**Subject: Environmental Impact Statement – Greater Parramatta, Olympic Peninsula (GPOP) Water Cycle (SSI-74258485) (City of Ryde, City of Parramatta, City of Canada Bay)**

**CPHR comments on the Environmental Impact Statement – Greater Parramatta, Olympic Peninsula (GPOP) Water Cycle (SSI-74258485)**

Figure D-2 Change in Flood Level - Design versus Base Case 50% of PMF Event

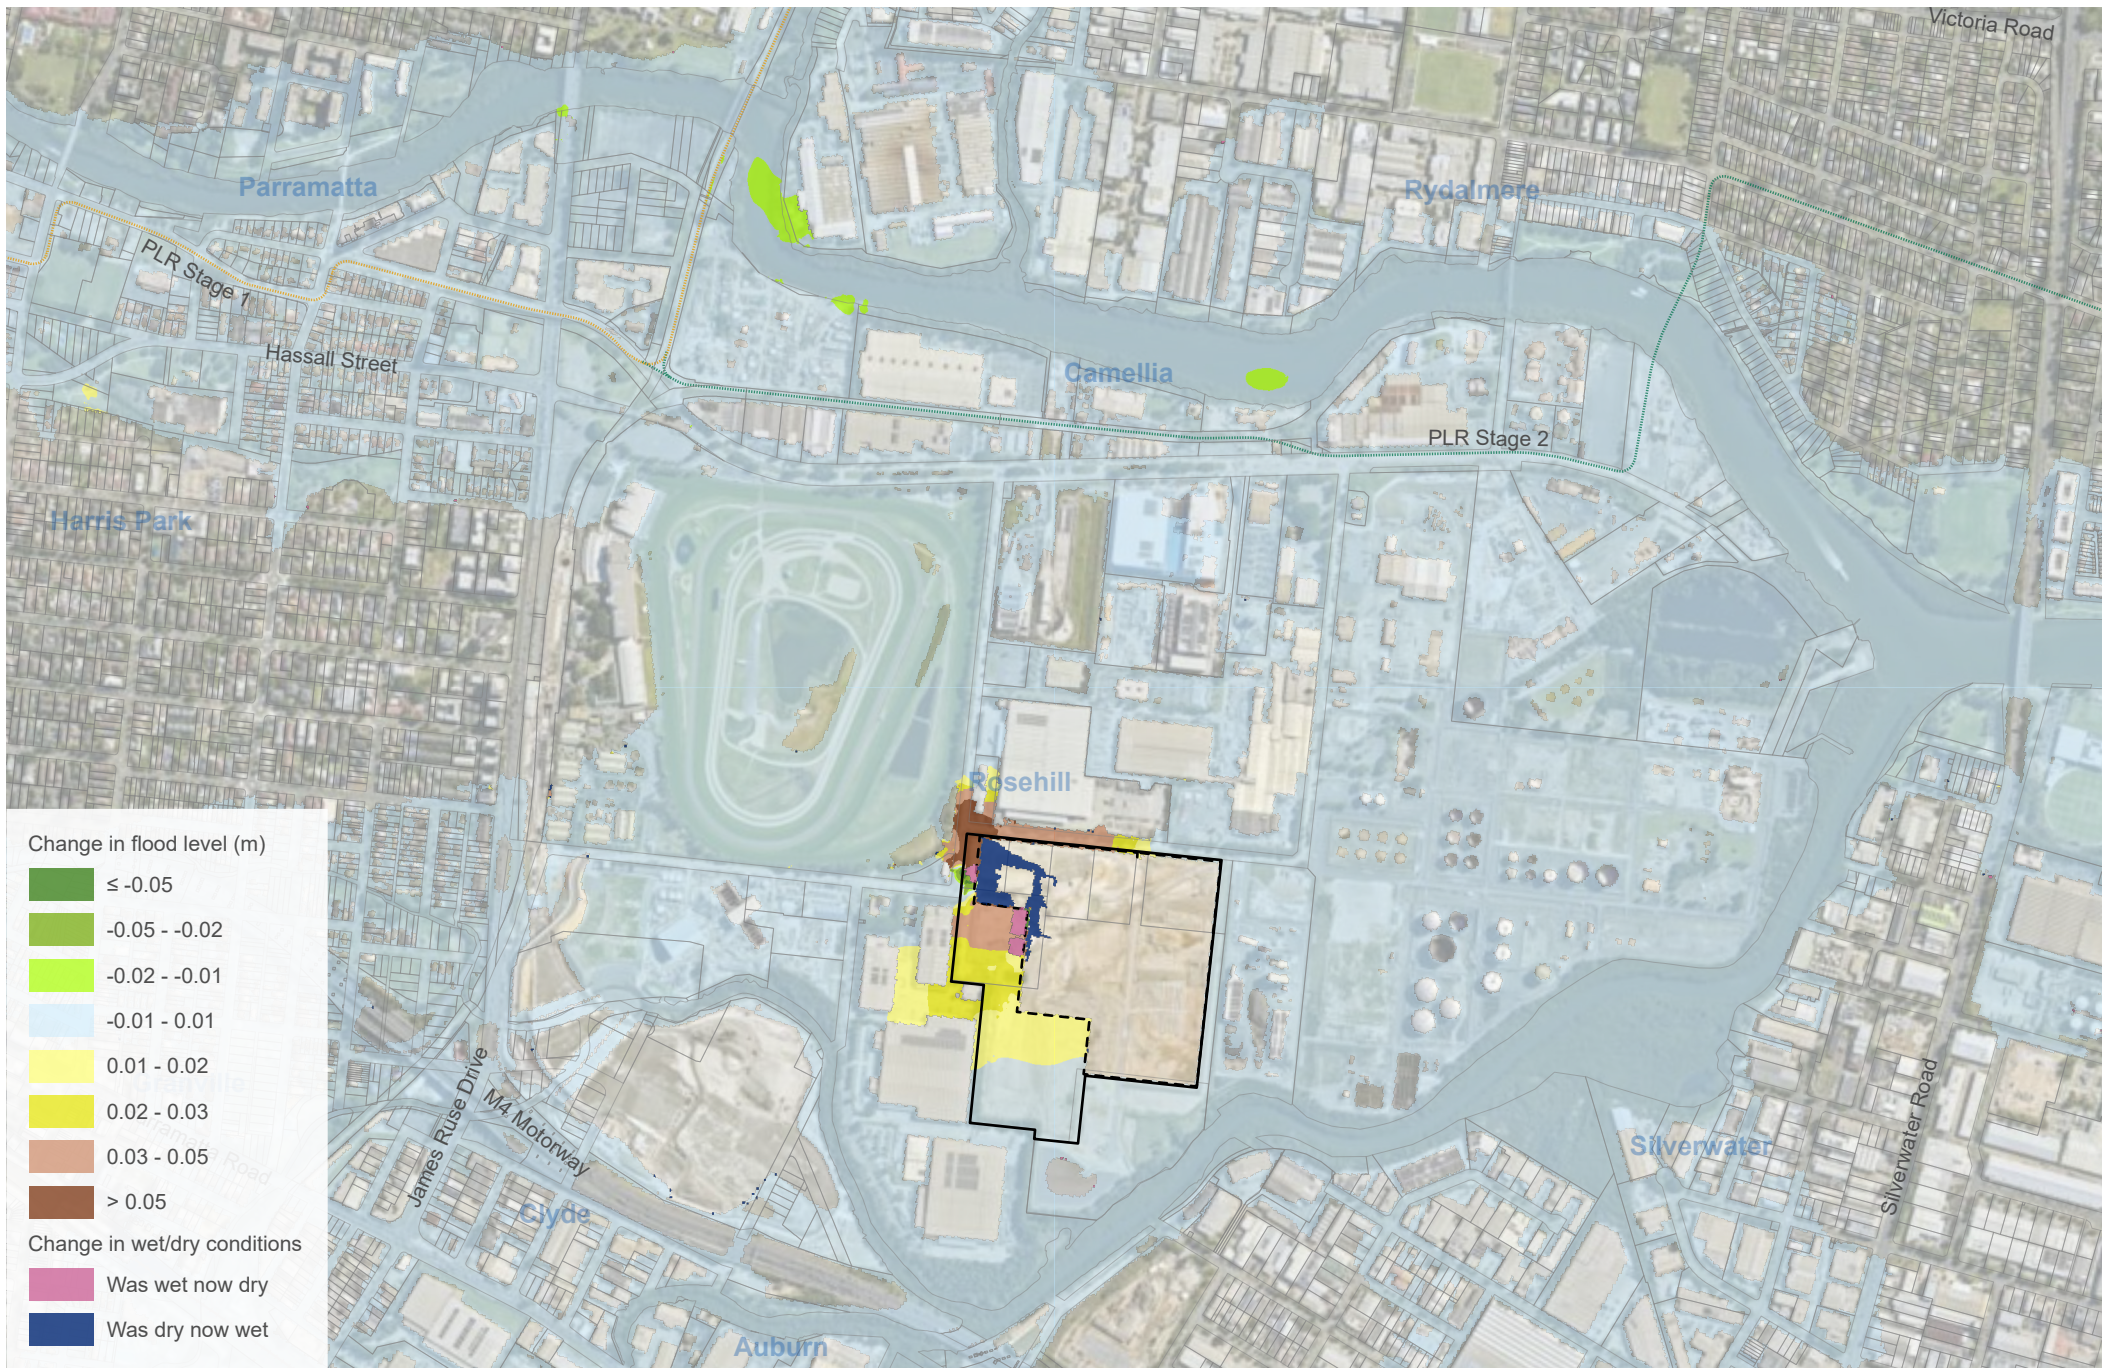
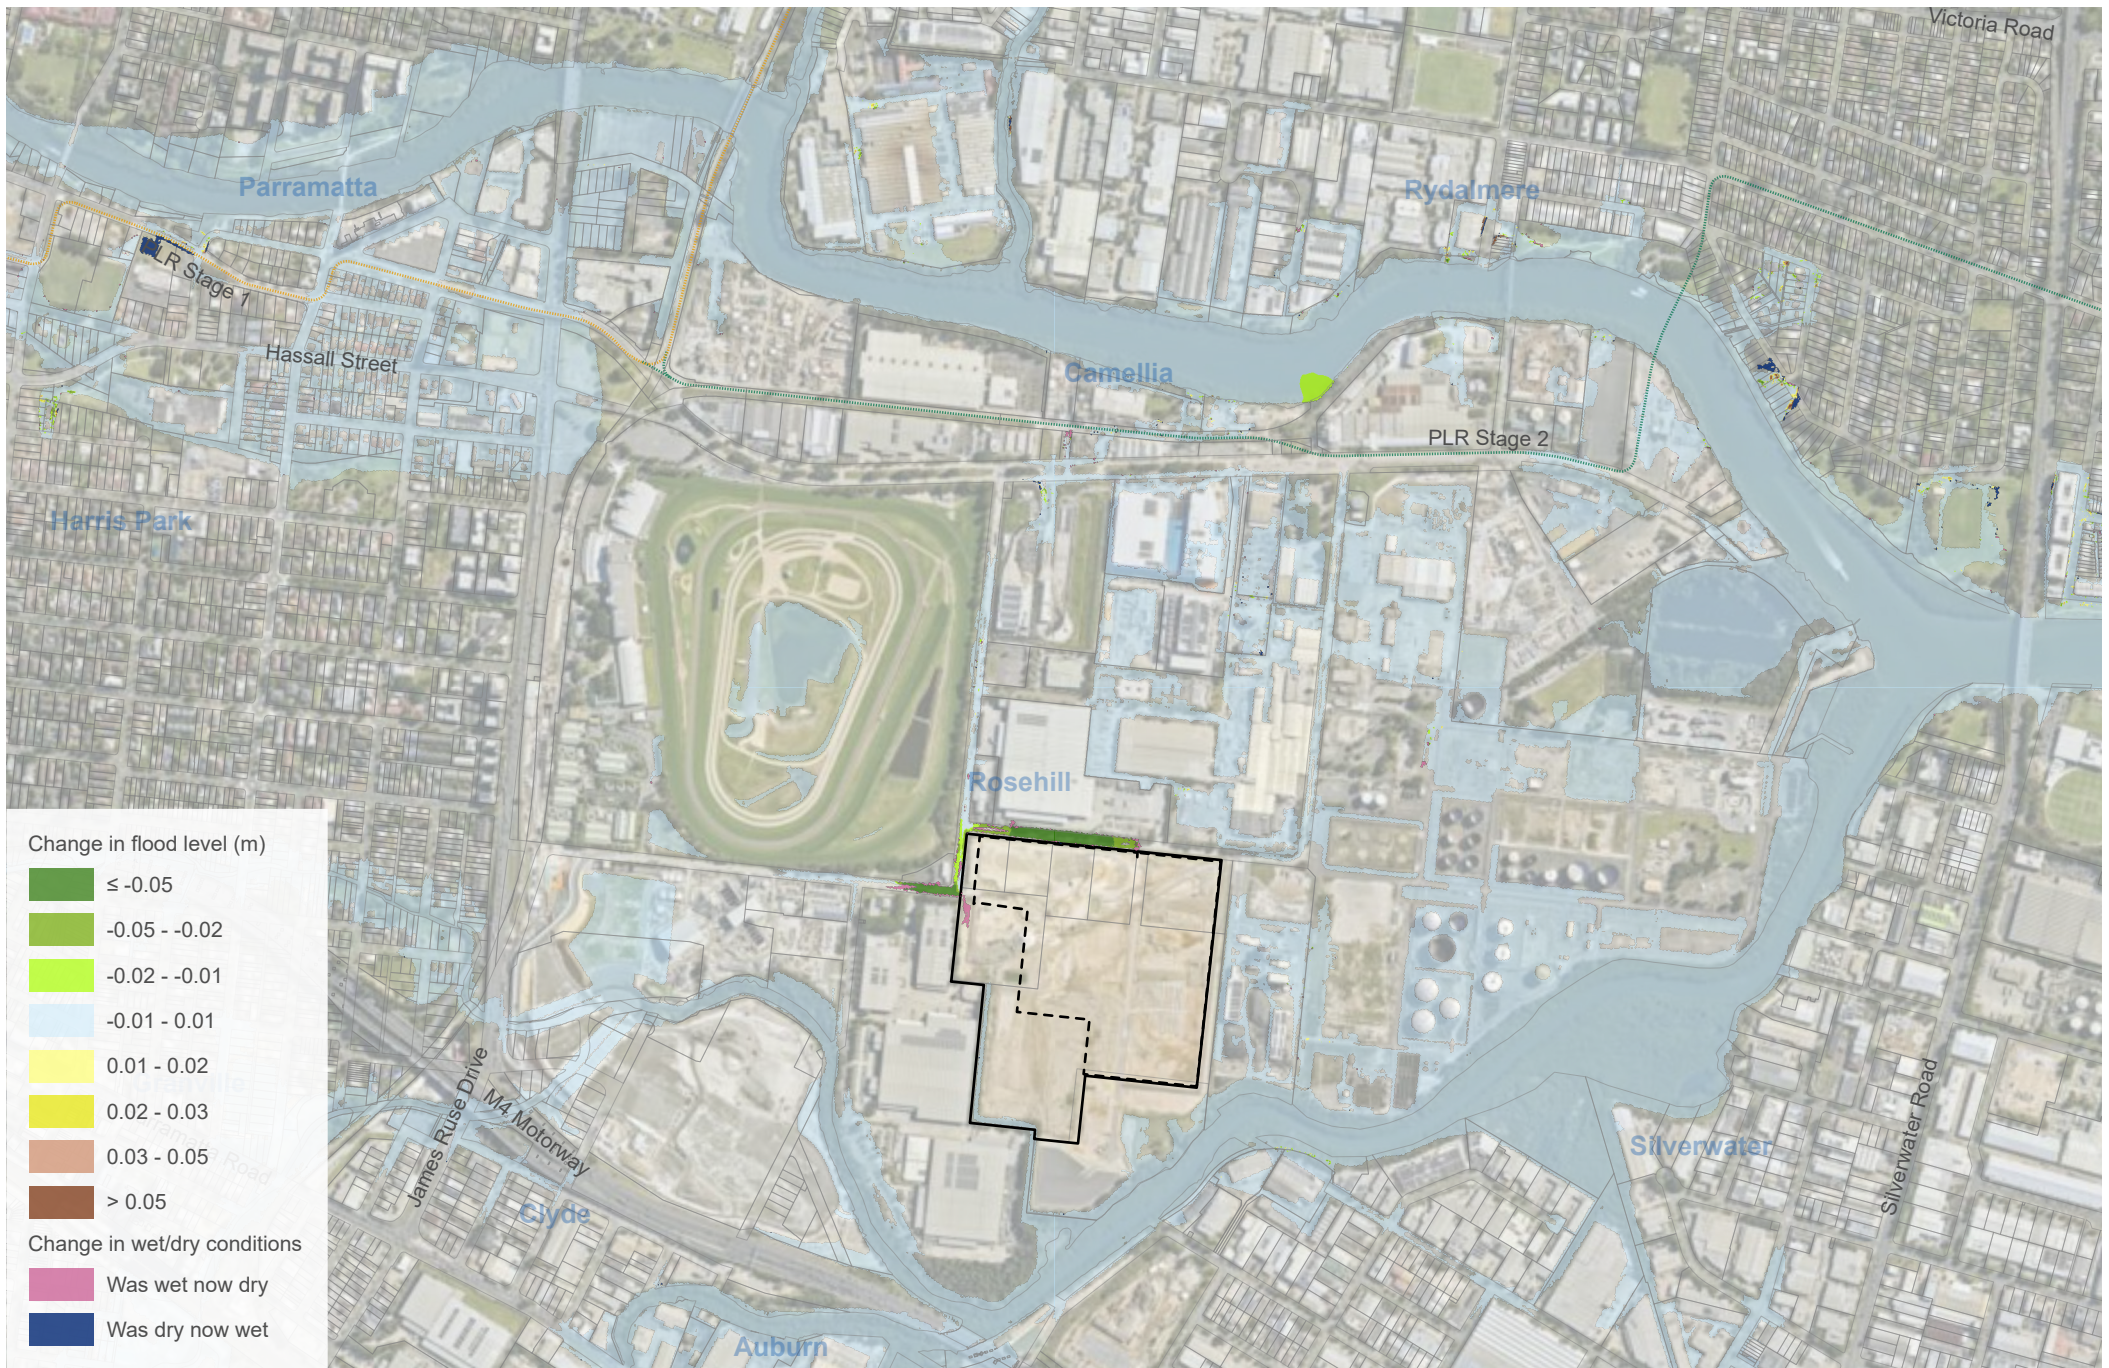
4.	<i>Design case flood and climate change mapping not provided</i>	<p>Appendix D of the FAR only contains flood impact mapping. CPHR advises that the design case flood mapping should also be included in the FAR.</p> <p>Furthermore, mapping of flood behaviour in climate change scenarios should be provided in accordance with the <a href="#">Flood Risk Management Manual</a> and NSW Flood Prone Land Policy.</p> <p><b>Recommended action:</b></p> <p>Revise the FAR to include both the design case and climate change results.</p>
	<i>Extent and Timing</i>	Response to Submissions
